3. UTILITIES

Attn: Stephen R. Bushey, P.E.
Re: Multi-Unit Commercial Building; 421 Warren Avenue, Portland
Ability to Serve with PWD Water

**Subject: 421 Warren Avenue Multi Unit Commercial Building
Wastewater Capacity Application**

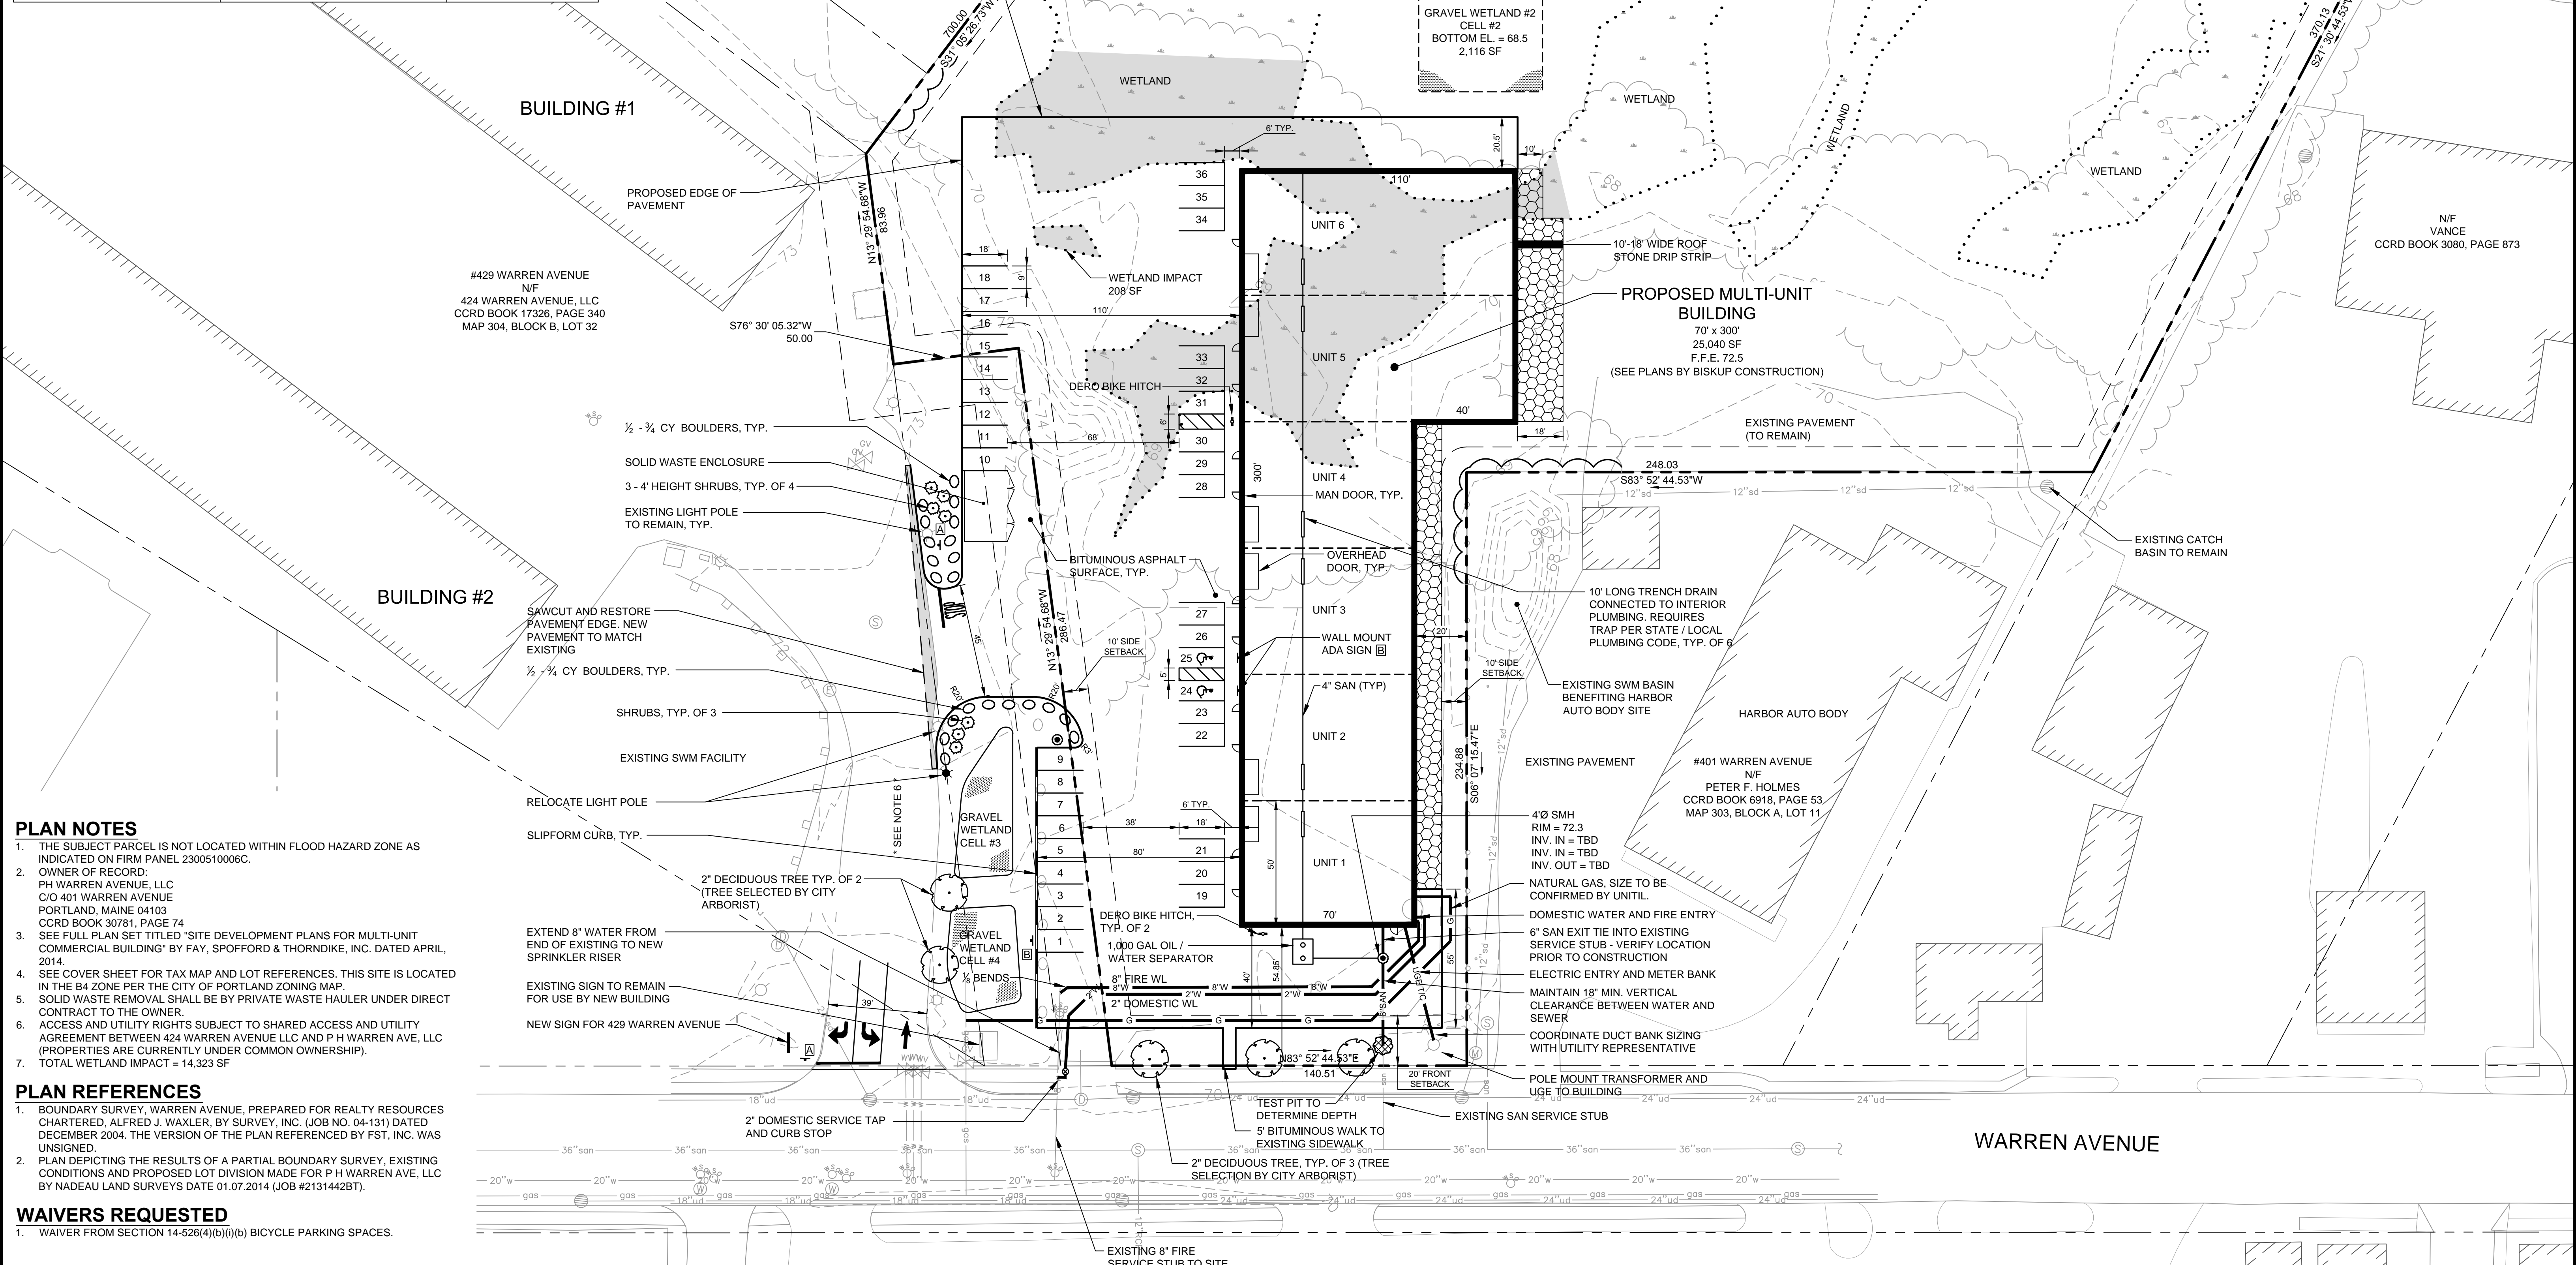
The District can confirm that the existing water system has the capacity to serve the proposed 7-unit commercial complex. We have reviewed the Site Layout and Utility Plan dated February 12, 2014 and have the following comment: Our records indicate that there is an existing 8-inch gate valve on the fire service at the street line. This valve should remain, and the domestic tap should be made prior to this gate valve so that the District will have a control valve on each service, which will allow them to be operated them independently.
